Freedom Forever
Planset Revision Letter

6/29/2023
REV #2

KONG THAO
300 HORSE WHISPERER LANE, LILLINGTON, NC 27546

ROOF MOUNT PHOTOVOLTAIC SYSTEM

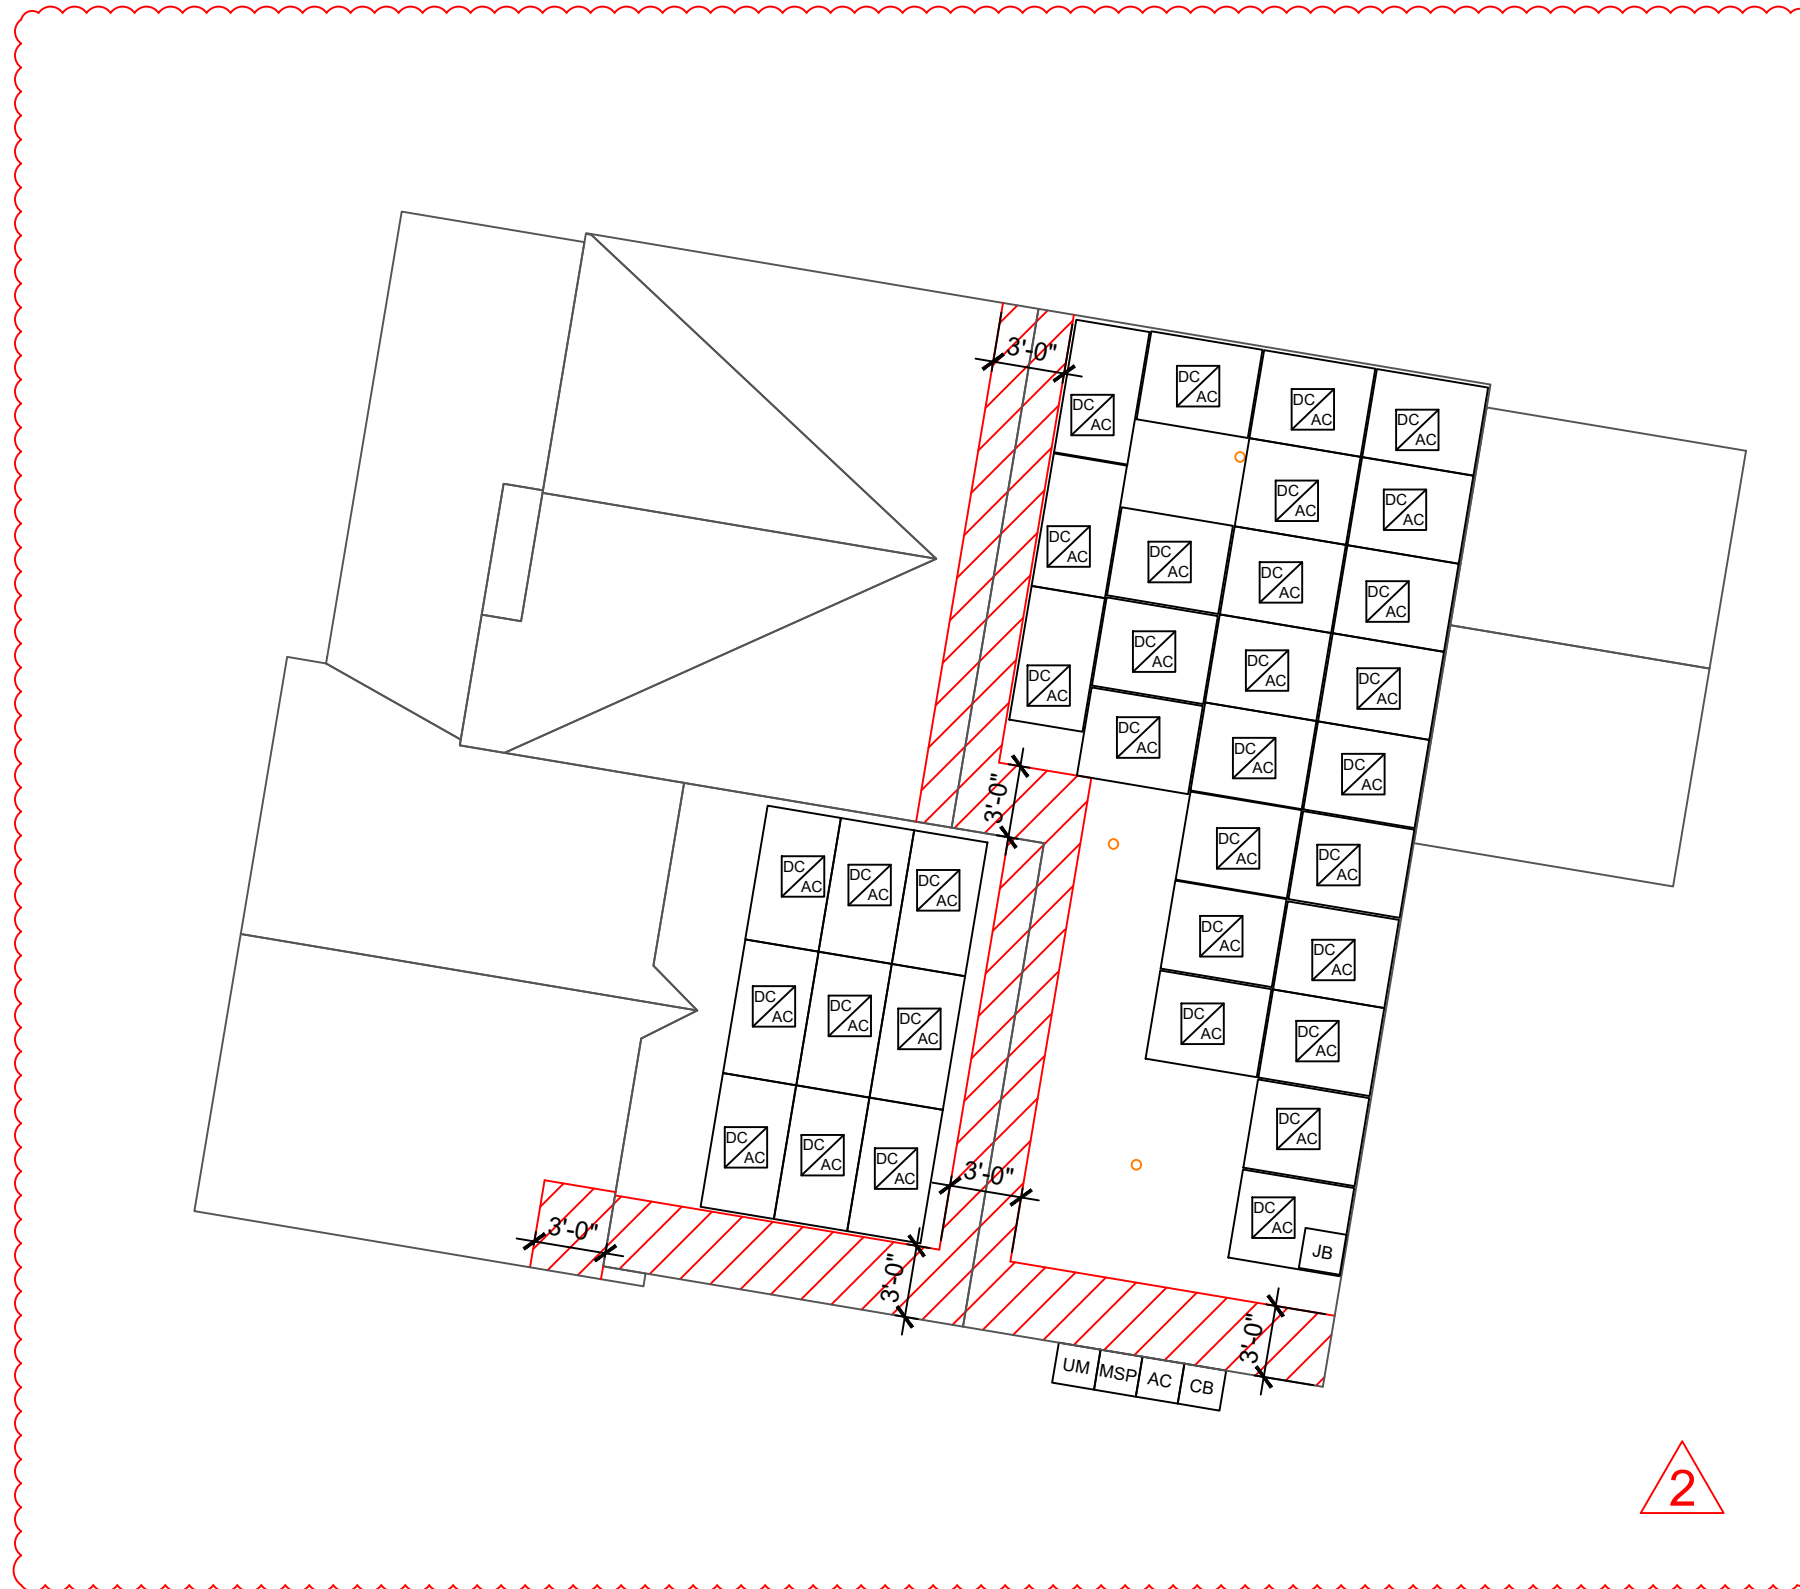
Layout change

All corresponding changes are notated on the plans by revision clouds.
